88 Preble Street

Attached is my memo for 88 Preble Street. I reviewed the updated plans, and didn't have any additional comments to add. My comments are VERY minor – just a few tiny detail updates.

2016.08.21 Preble Street Peer Review Memo.docx
55K

ISSUE DATE 8/2/16
DRAWN BY SWC
SHEET TITLE Grading and Drainage Plan

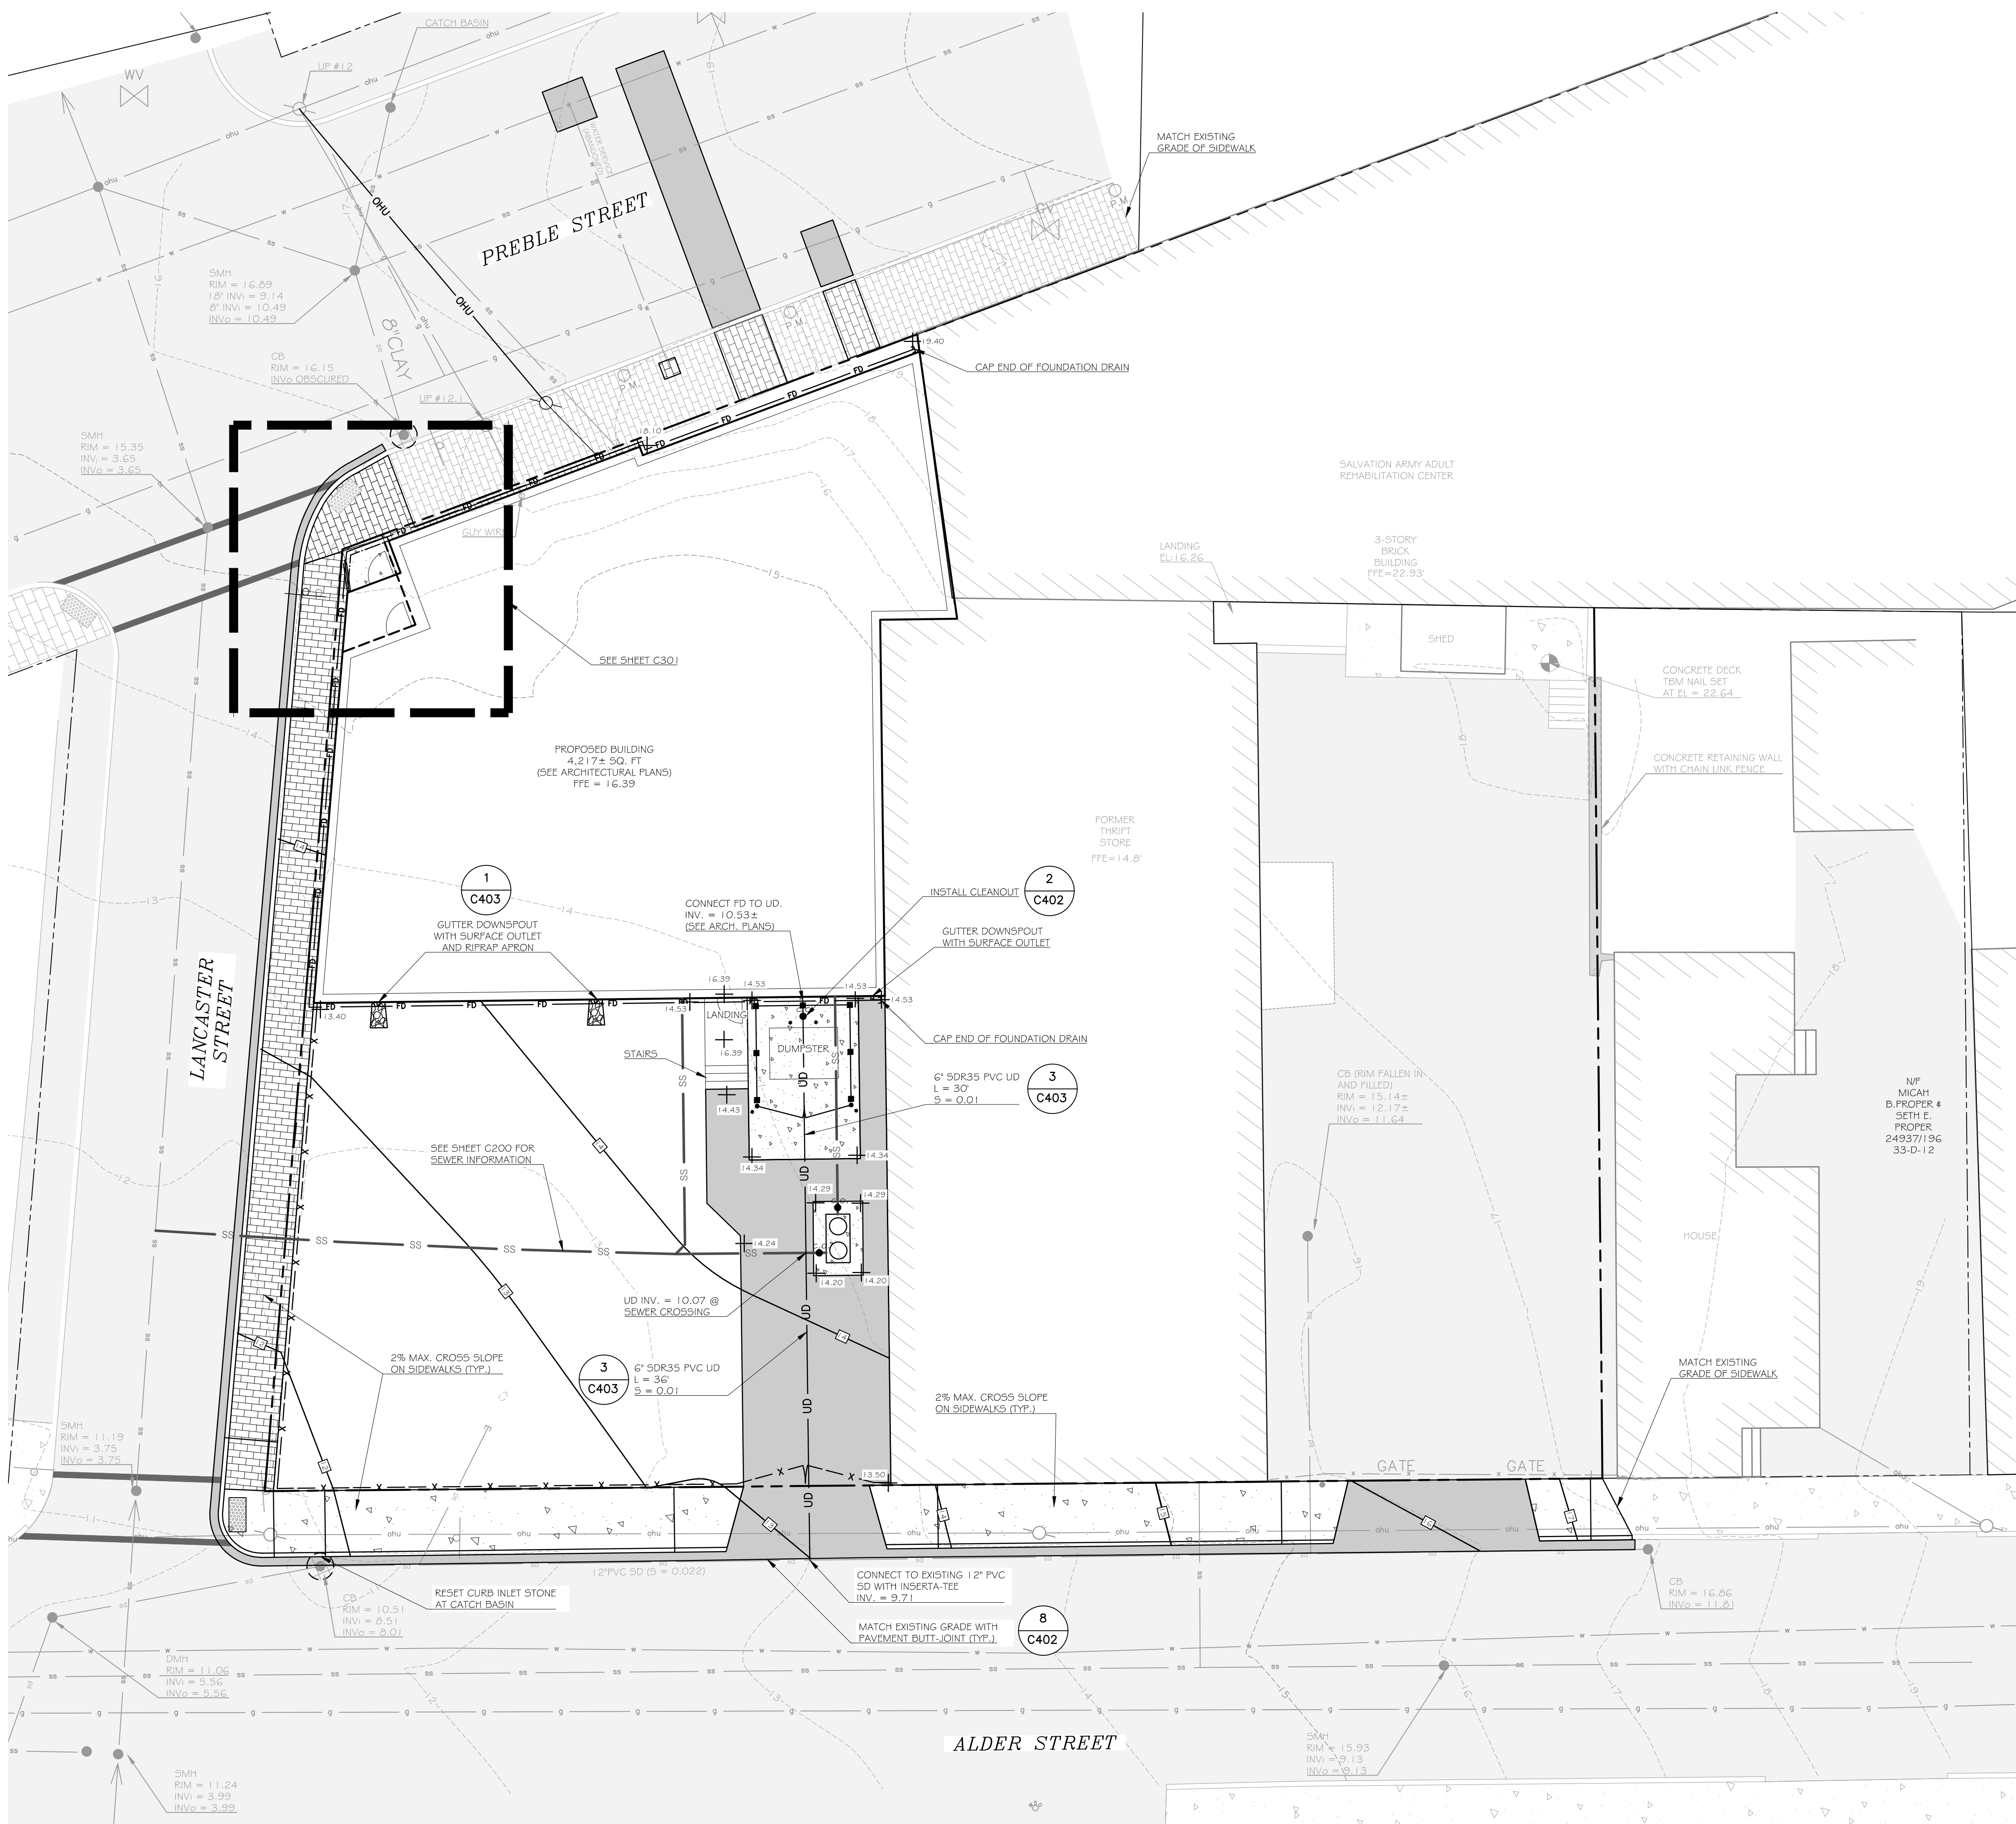
Brad, they are tying their foundation drain into the storm drain on Alder (I've asked for a detail of the connection) and are tying their sewer service into the sewer on Lancaster. Roof drainage is surface flow from downspouts, and they are decreasing impervious surface area, so there are no stormwater concerns. They are using a grease trap, so I included a note to contact Rachel Smith to confirm sizing (per Dave M-P's prior standard comments). They are demolishing an existing storm drain connection, so I've asked for some details on how they are going to do that.
